**Colorado Springs, CO
Planning and Development**

Final Report - Corrections Required
Application No. ANEX-23-0010

Description : A request by Norris Ranch Joint Venture, LLC, for annexation of 4.823 acres into the City of Colorado Springs. The annexation is a part of the overall Karman Line Land Use Plan, which is being submitted concurrently. The Land Use Plan proposes a maximum of 6,500 dwelling units, approximately 45 acres of light industrial, 105 acres of commercial/retail, 100 acres of mixed-use development, and 570 acres of park/open space.

Document Filename : KARMAN 2 2023-03-27.pdf

ANNEXATION PLAT KARMAN LINE NO. 2

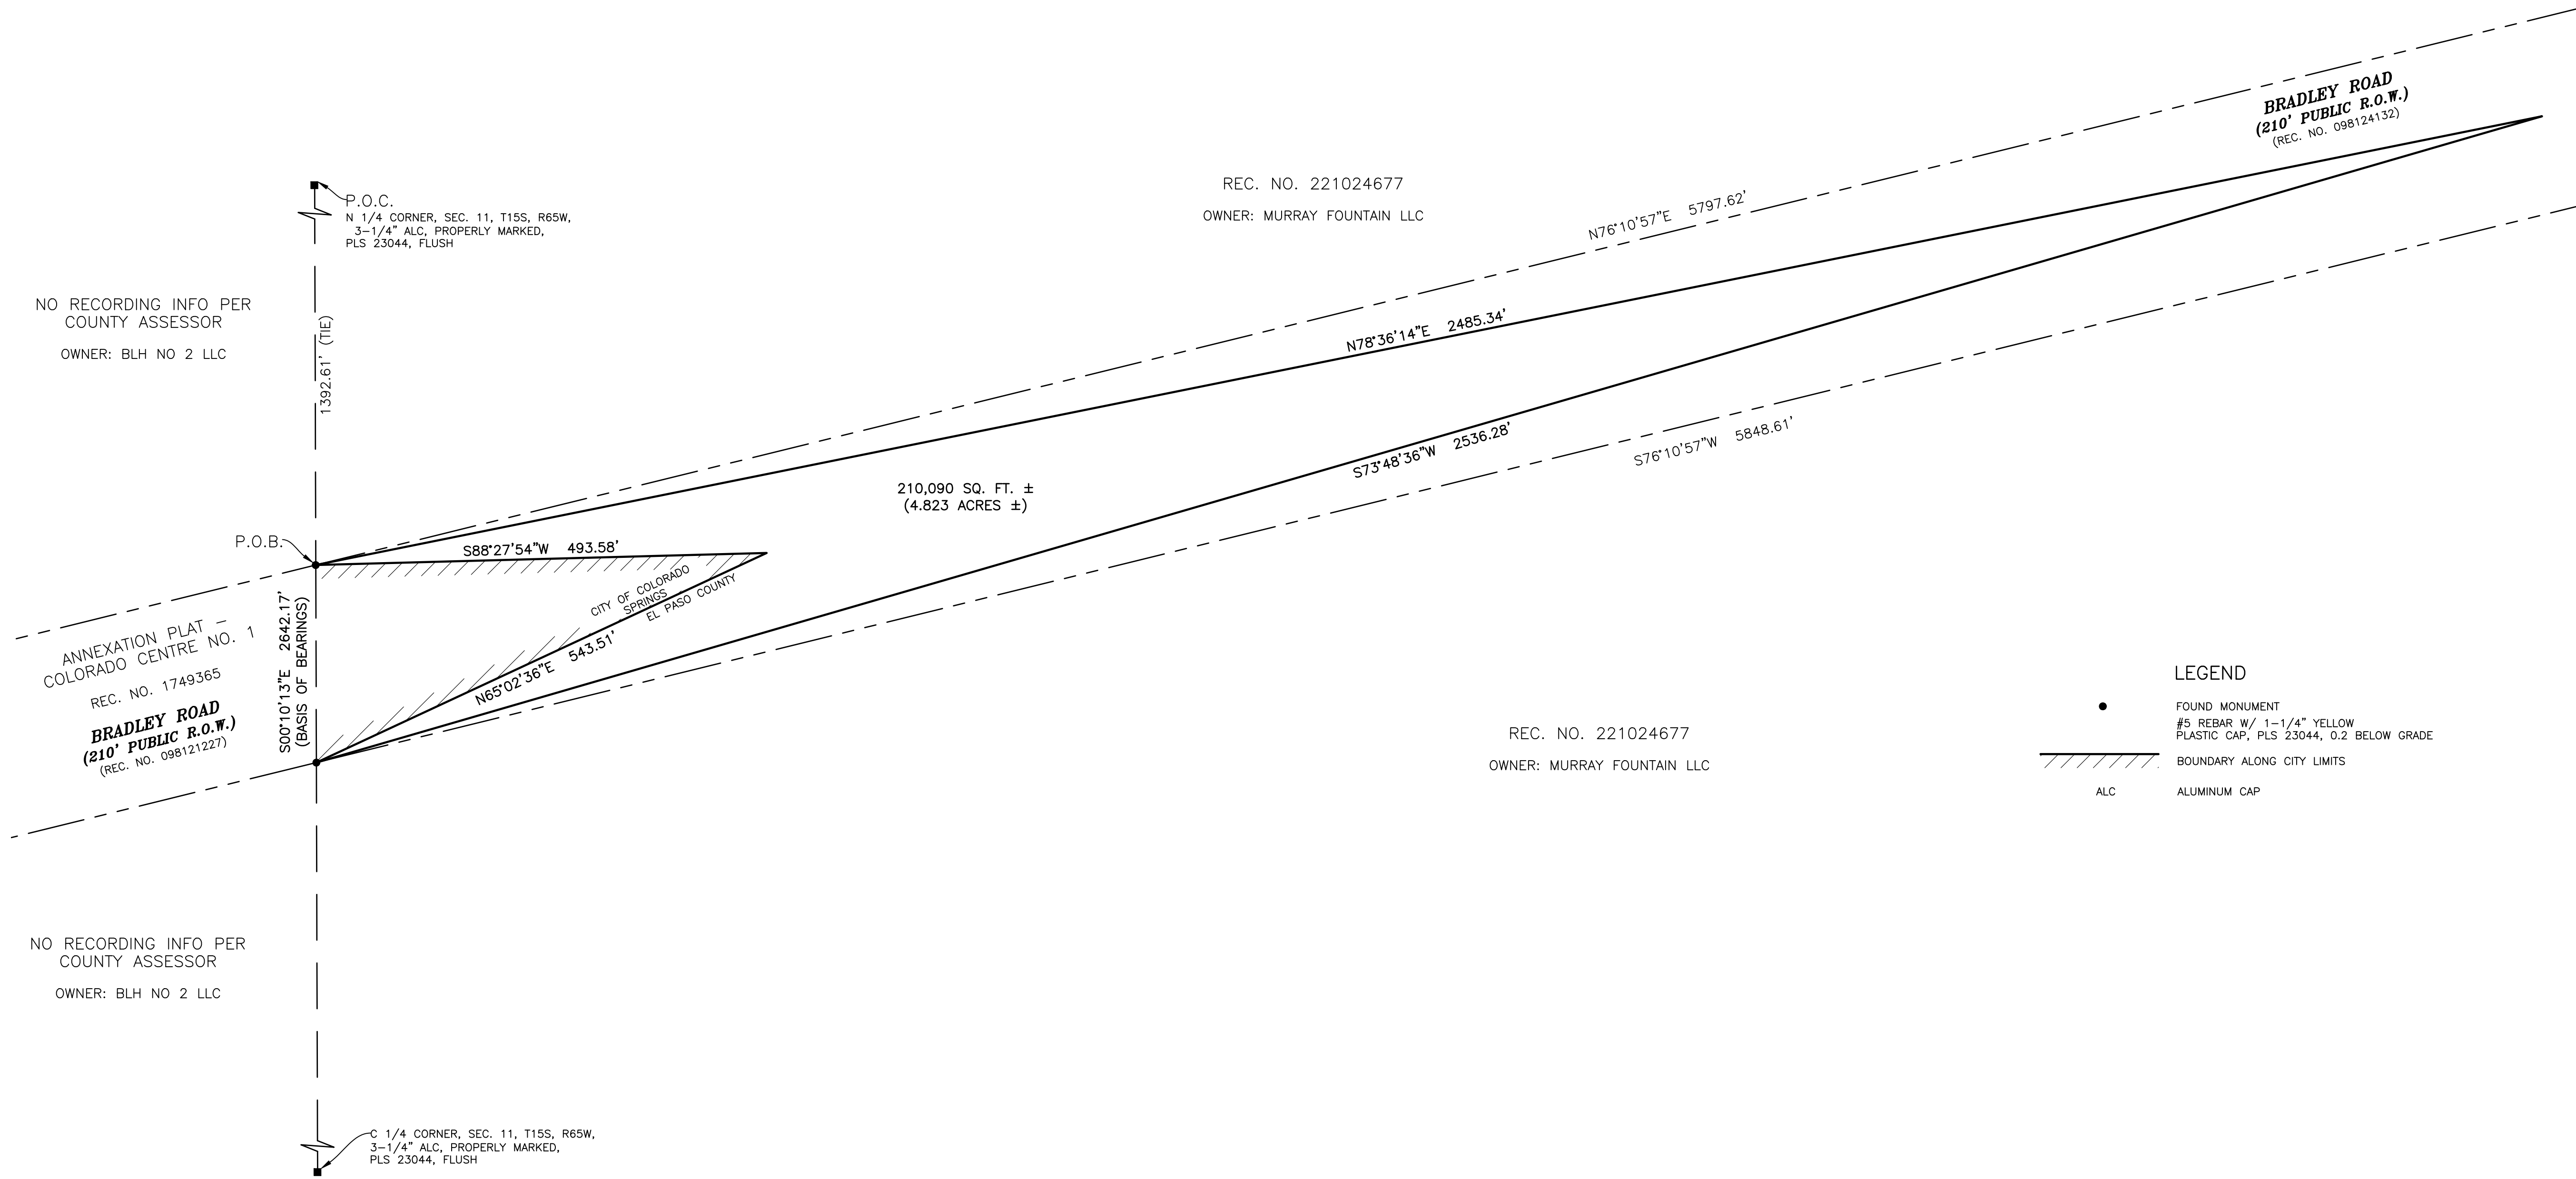
-	1	Cory Sharp : Planning	
-	1	Cory Sharp : Planning	
3	1	Cory Sharp : Planning	Please update the name Karman Line Addition No. 2
4	1	Cory Sharp : Planning	Please update the name Karman Line Addition No. 2
5	1	Cory Sharp : Planning	Please check revise the total, 6058.71'
6	1	Cory Sharp : Planning	Please check/revise the percent 17%
7	1	Cory Sharp : Planning	Please update the Recorder's name: Steve Schleiker, Recorder
8	1	Cory Sharp : Planning	Please update the City File No. ANEX-23-0010
9	1	Cory Sharp : Planning	Please update the name Karman Line Addition No. 2
10	1	Cory Sharp : Planning	Please remove the El Paso County signature and notary
11	1	Cory Sharp : Planning	<p>Please update the ownership: Owner: The aforementioned, City of Colorado Springs, Colorado, a home rule city and Colorado Municipal Corporation, has executed this instrument this __ day of _____, 20__ A.D.</p>

18	2	Cory Sharp : Planning	Please update the name Karman Line Addition No. 2
19	2	Cory Sharp : Planning	Please update the name Karman Line Addition No. 2
20	2	Cory Sharp : Planning	Please update the City File No. ANEX-23-0010
21	2	Cory Sharp : Planning	Please update the reception no. for Bradley Road 222103960
22	2	Cory Sharp : Planning	Please update the reception no. for Bradley Road 222103960
30	2	Dan Sexton : Planning	Please revise the recordation information for this adjacent parcel. The reception number is: 222051558.
31	2	Dan Sexton : Planning	Please update the recordation information for this adjacent parcel. The El Paso County Assessor's website documents a number of reception numbers for the parcel.

Comment ID	Page Reference	Author : Department	Review Comments
32	2	Dan Sexton : Planning	Please add "*Unplatted*" labeling for all adjacent parcels that are not platted.
33	2	Dan Sexton : Planning	Please add "*Unplatted*" labeling for all adjacent parcels that are not platted.
37	2	Dan Sexton : Planning	Please label as Karman Line Addition No. 1
